From: Simon Davis
Sent: 10 February 2022 10:49
To: Planning Scanning
Subject: FW: 2087: AL/129/21 - Land adjacent Woodgate Nurseries, A29 Lidsey Road, Woodgate - Departure from Standards applications in Word Format

From: Tim Townsend [REDACTED]
Sent: 09 February 2022 11:54
To: brad.loxley [REDACTED]; Henry Moyo [REDACTED]
Cc: dave.tighe [REDACTED]; Simon Davis [REDACTED]
Subject: RE: 2087: AL/129/21 - Land adjacent Woodgate Nurseries, A29 Lidsey Road, Woodgate - Departure from Standards applications in Word Format

Design and Departures from Standard.

Figure 4.2 – Proposed site access junction

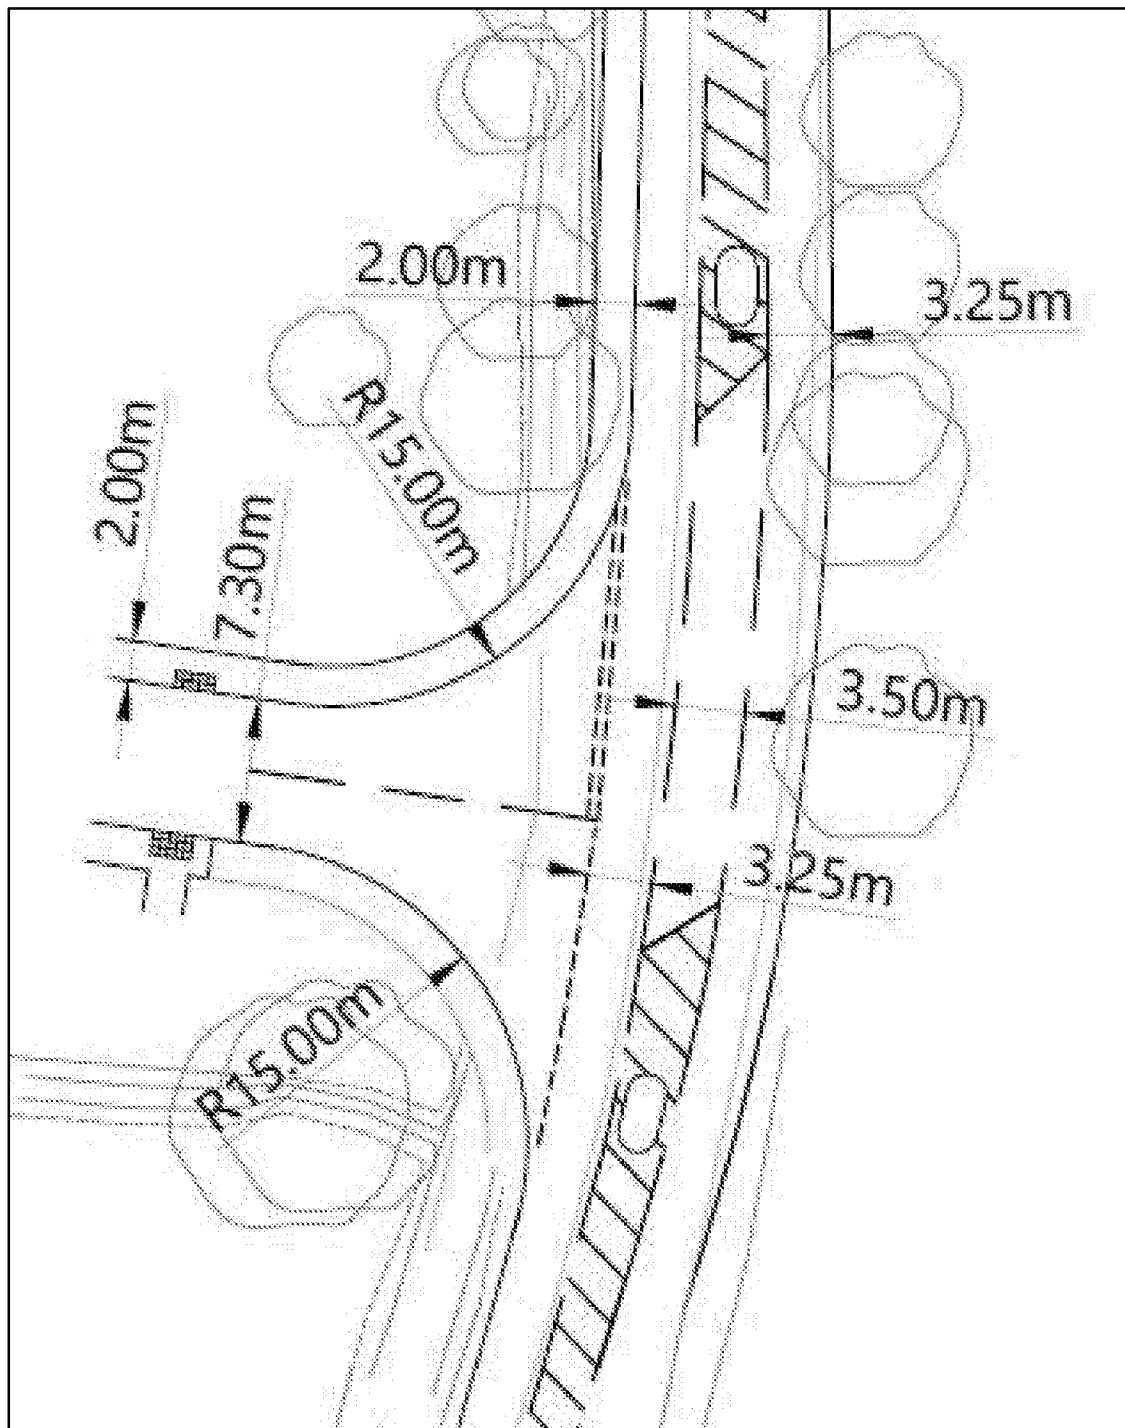
1. On the application form, a deceleration lane of 18m is proposed as opposed to 55m that is required on a road with a design speed of 50mph (Note: 50mph is the design speed given on the form). On the form there are no details of why a right turn lane meeting the standard (CD 123) cannot be provided. Existing highway boundary information or land ownership is not detailed on the drawings. The proposed 18m deceleration lane length does not meet the minimum recommended length even for a 30mph speed limit, which is 25m. It is likely that vehicles will be accelerating away from the end of the 30mph speed limit area and so speeds will be higher than 30mph, possibly closer to the 50mph posted speed limit at the proposed right turn lane.

2. There are no compensatory measures proposed to mitigate the effect of reduced deceleration lane.
3. The designer should review the central island hatching on the northern end of the right turn lane. It could be that the hatching starts further north, thereby increasing the turning length. The orientation of the line at the start of the northern hatching should also be reviewed.

4. Islands are proposed on either side of the access but is unclear if they are traffic islands or pedestrian refuge islands. Pedestrian refuge islands on a high speed road can only be provided if supported by an approved departure from standard application.
5. General: - Designers to ensure that visibility splays are within the existing highway or in land that is in the control of the developers (noted as now shown on Drawing No.38 from Project 2087 dated 02.02.2022 as supplied with your further email, also dated 8 February 2022).

A	Updated site access arrangements	BL	10.02.22
ISSUE	REASON FOR REVISION	BY	DATE

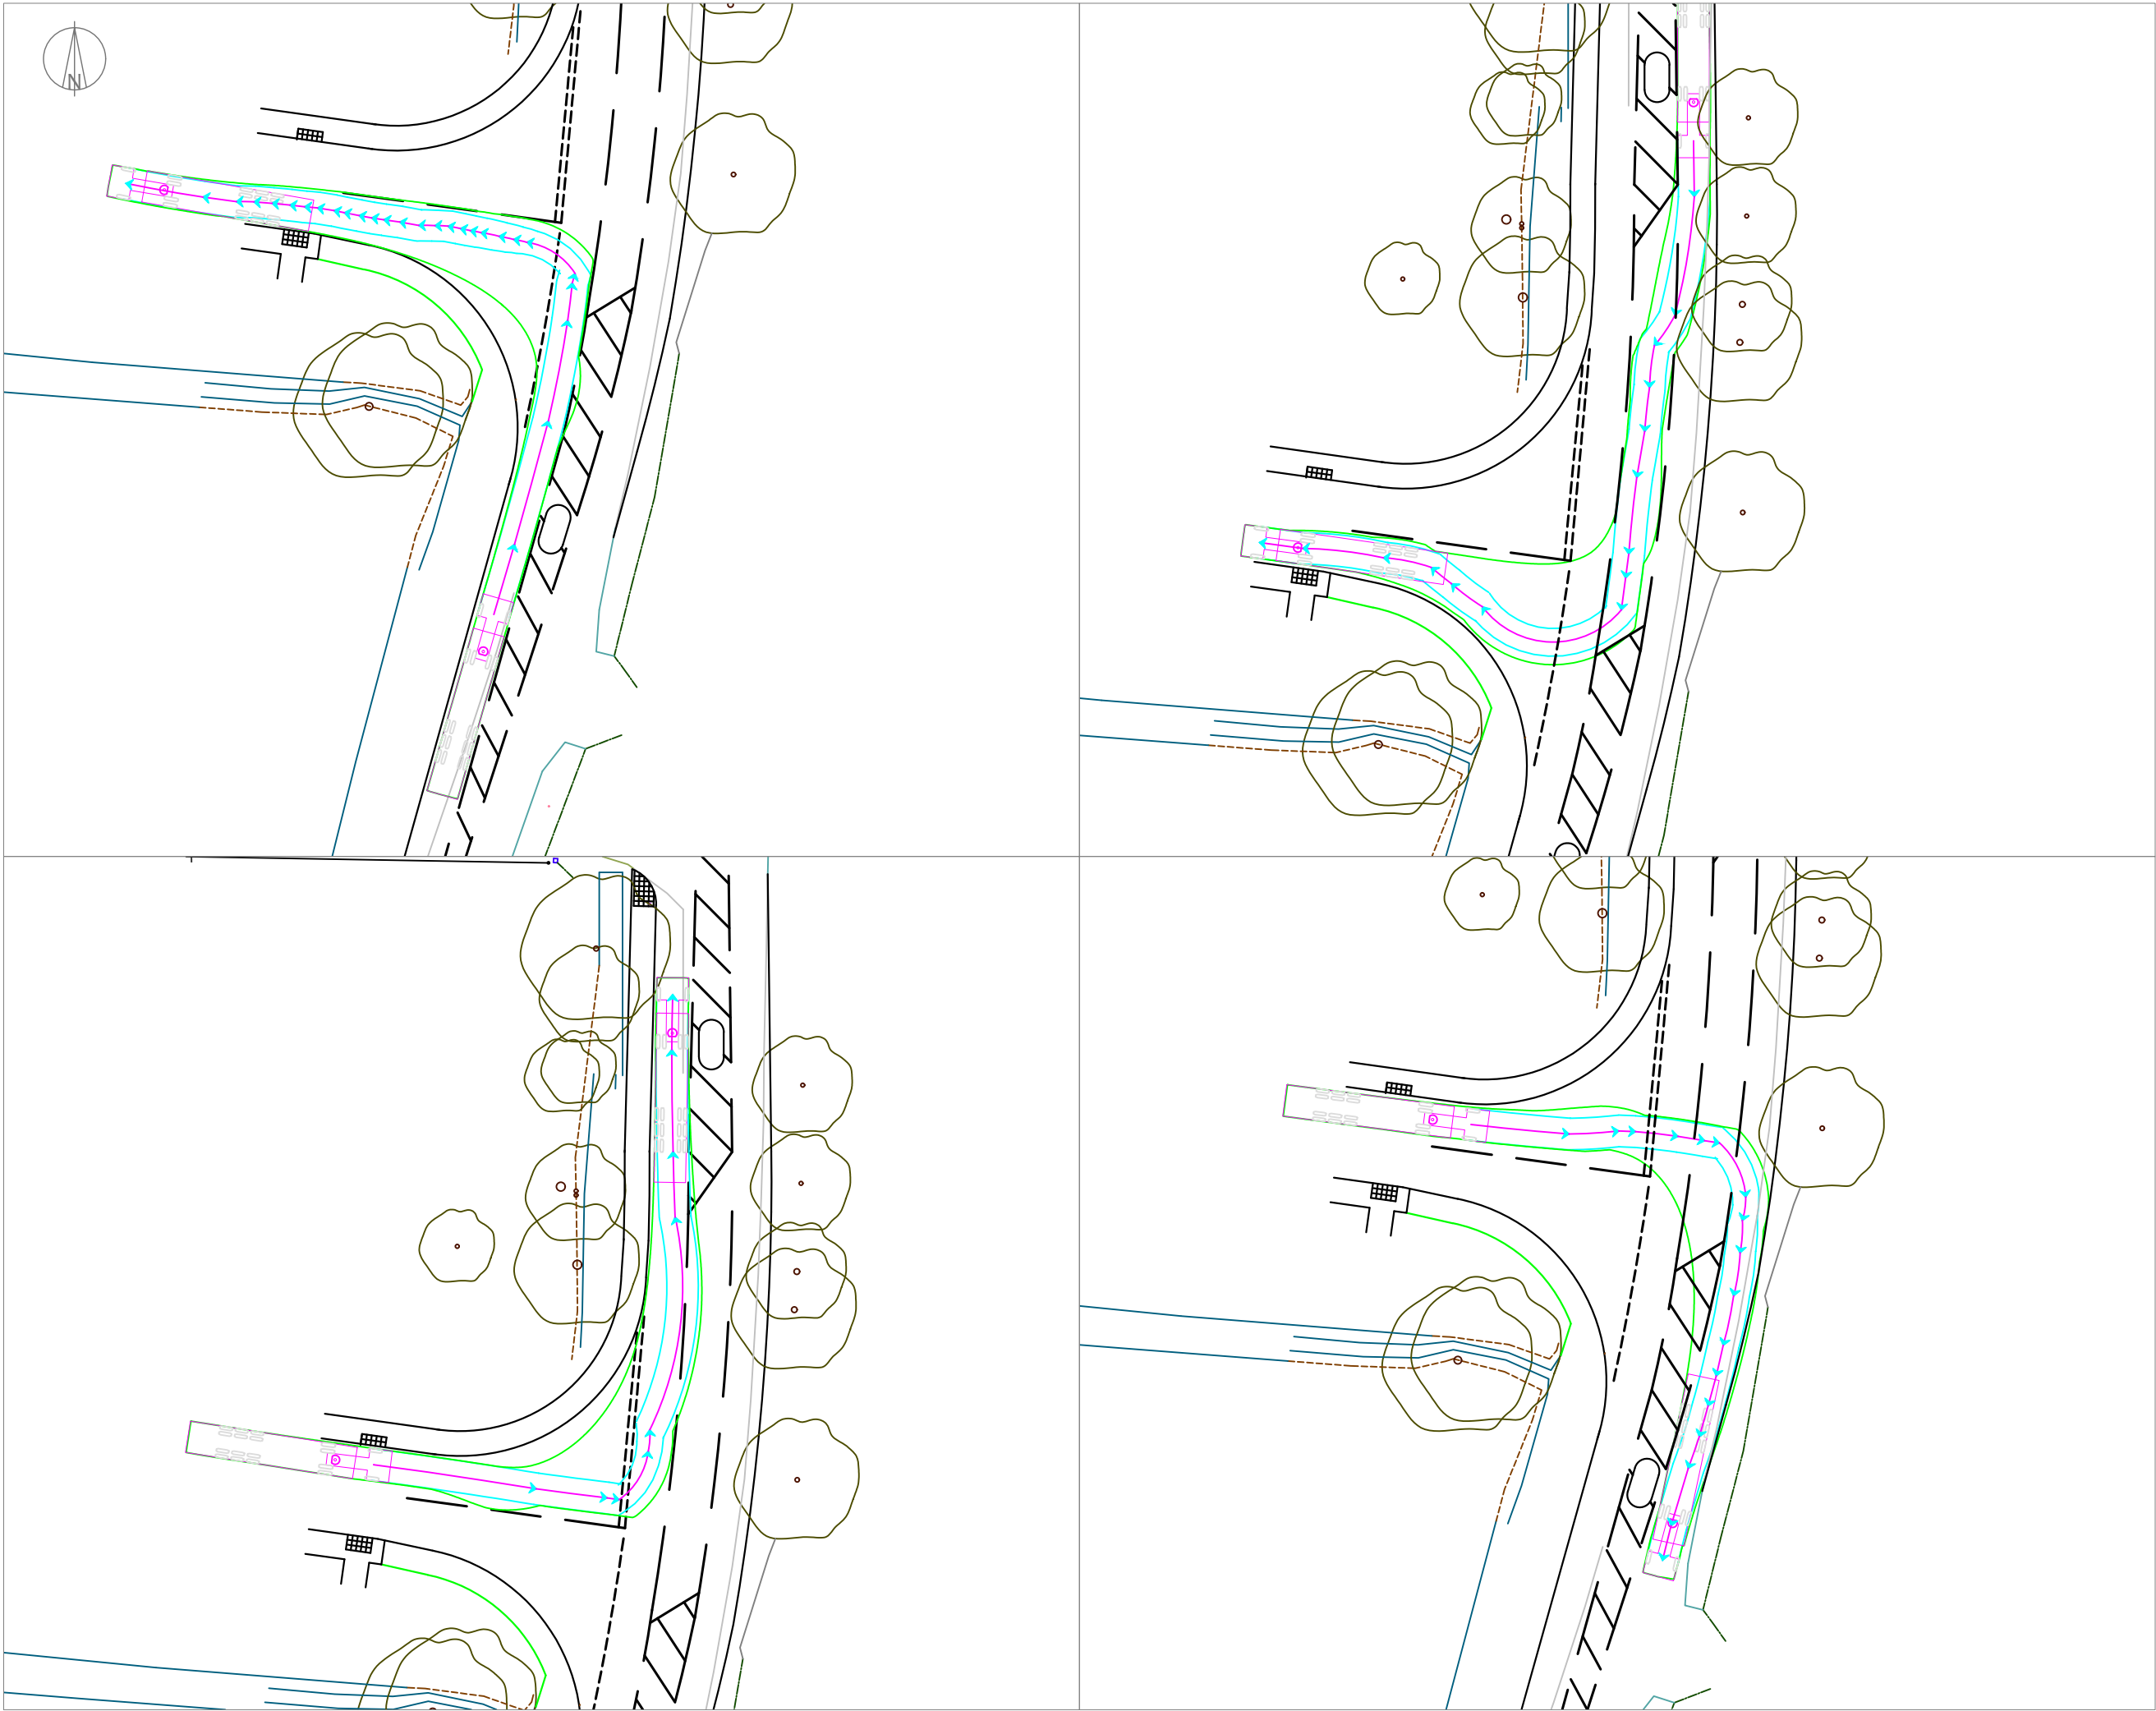
2. *Visibility at retained access to Woodgate House (drawing 2087/37)* – This is noted as being slightly increased over the existing arrangement.
3. *Confirmation of the central turning 'pocket'* – Please see comments above (points 1-5) under 2087/DFS/02.
